Recommendation Report for Planning Permission for Works or Extension to a Dwelling

REF NO: Y/16/22/HH

LOCATION: 2 Lilac Cottages
Church Lane
Yapton
BN18 0EH

PROPOSAL: Conversion of loft to habitable use including the installation of 1 x front dormer.

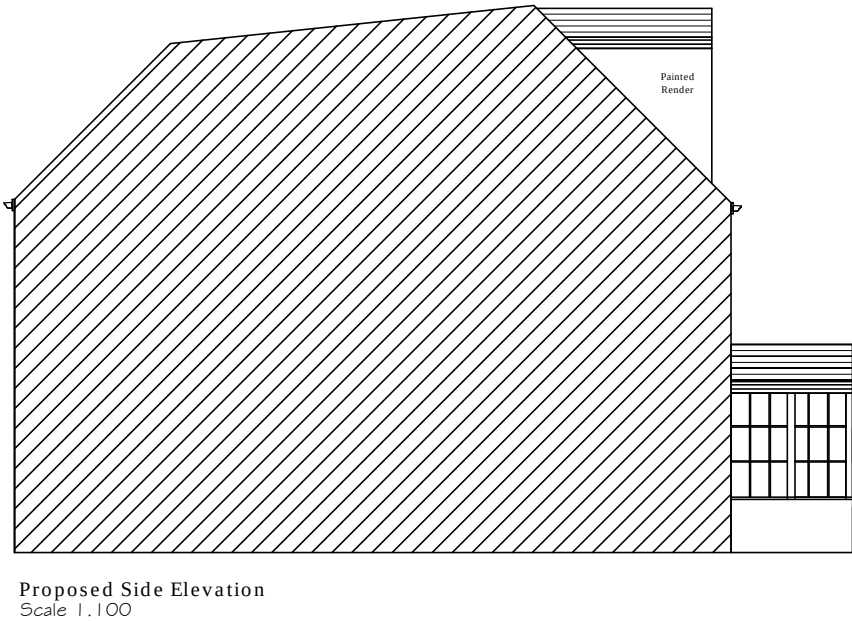
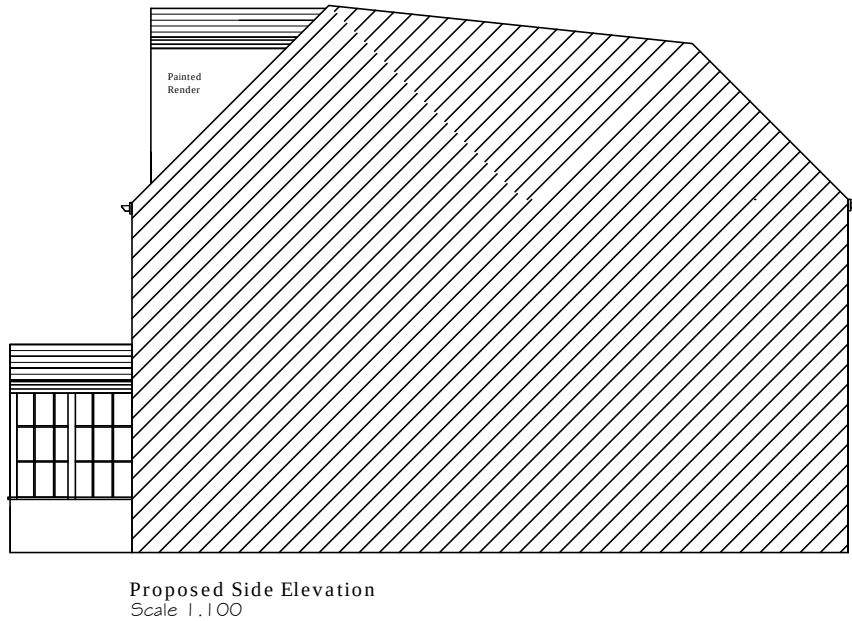
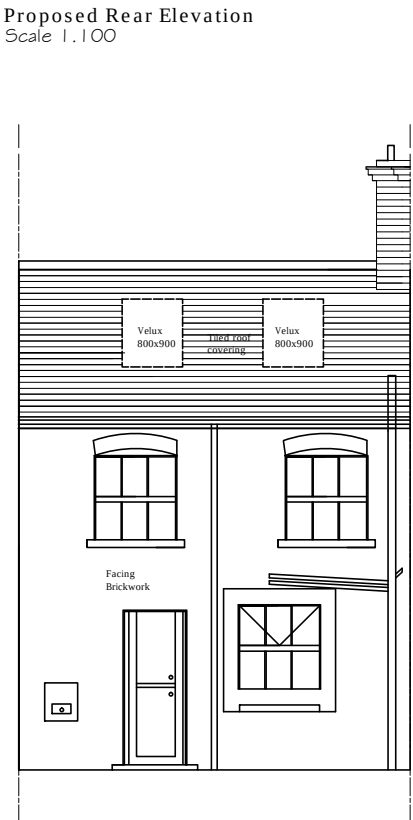
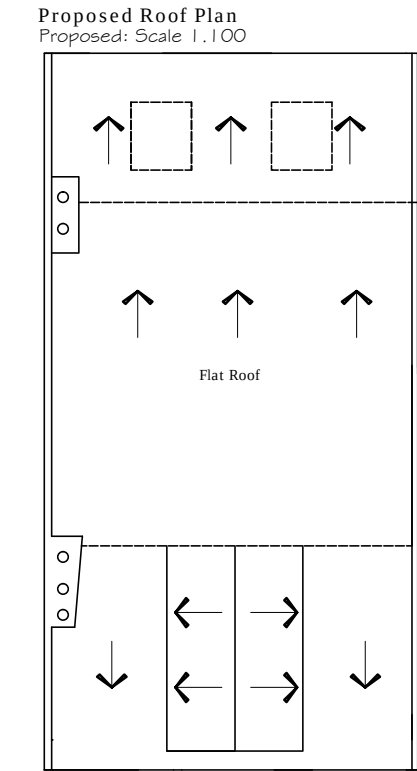
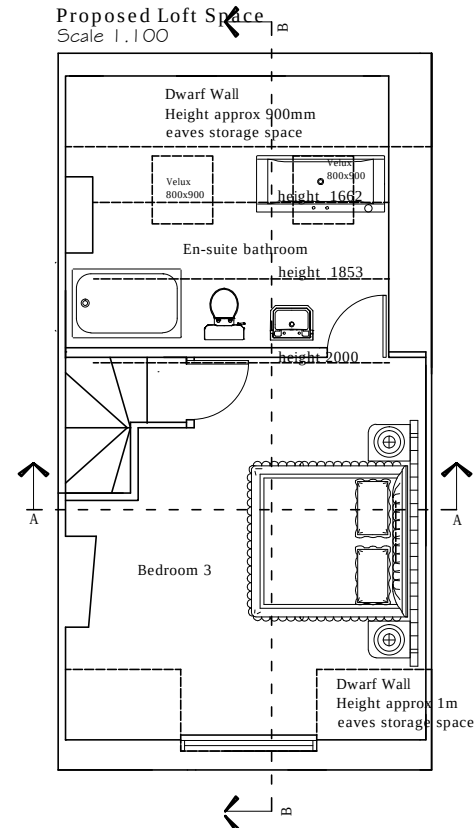
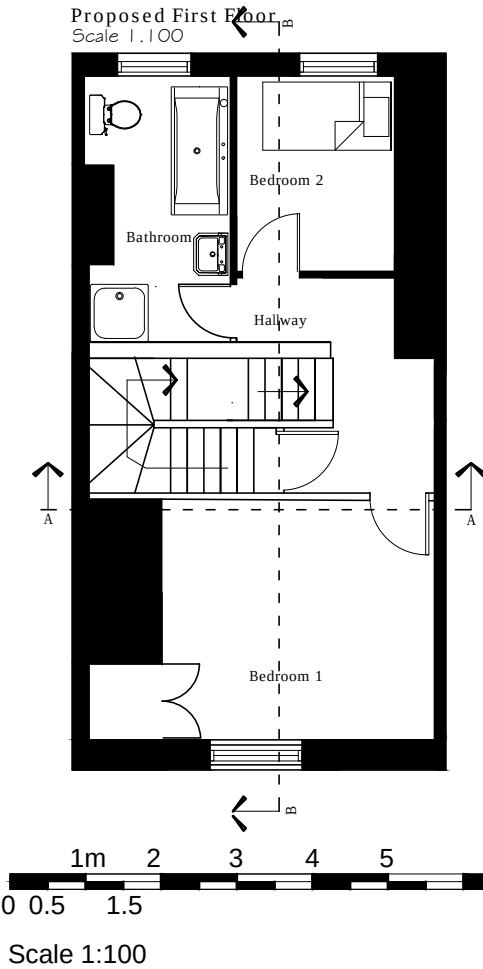
The dormer would front the street scene and be highly visible from the wider area. The front dormer appears well designed and will have a pitched roof. It is modest in size and appears appropriate in scale. Its position is centred on the roof, in line with the window and porch below. The dormer is acceptable in design.

To enable the loft conversion, the design of the roof will alter. Currently the main dwelling has 2 gable pitches and this will alter in such that a flat roof will be constructed between the pitches.

The roof alteration does not sympathetically relate to the existing dwelling and does not adhere to the roof form pattern identified in the neighbouring properties. This would result in a roof design that differs significantly from the neighbouring dwellings and will adversely impact the appearance of the property and result in the dwelling appearing out of character in relation to its neighbours.

As a result of the roof alteration, it would result in the dwelling appearing out of character and harm the appearance of the property in wider area in conflict with D DM1 (1) and D DM4 (a) (b) and (e) of the Arun Local Plan. It also conflicts with Section M of the Arun Design Guide.

Whilst it does not result in the removal of the structure as a whole, the proposal significantly alters the design of the m shaped roof which is a feature that contributes to the interest of the building, impacting negatively on the buildings character. The proposal conflicts with Policy HER DM2 of the Arun Local Plan.

- 1 The roof alteration by reason of its size and design results in adverse harm to a Building of Character and its appearance in relation to its neighbours and surrounding area in conflict with D DM1 (1) and D DM4 (a) (b) and (e) and HER DM2 of the Arun Local Plan and Section M of the Arun Design Guide.
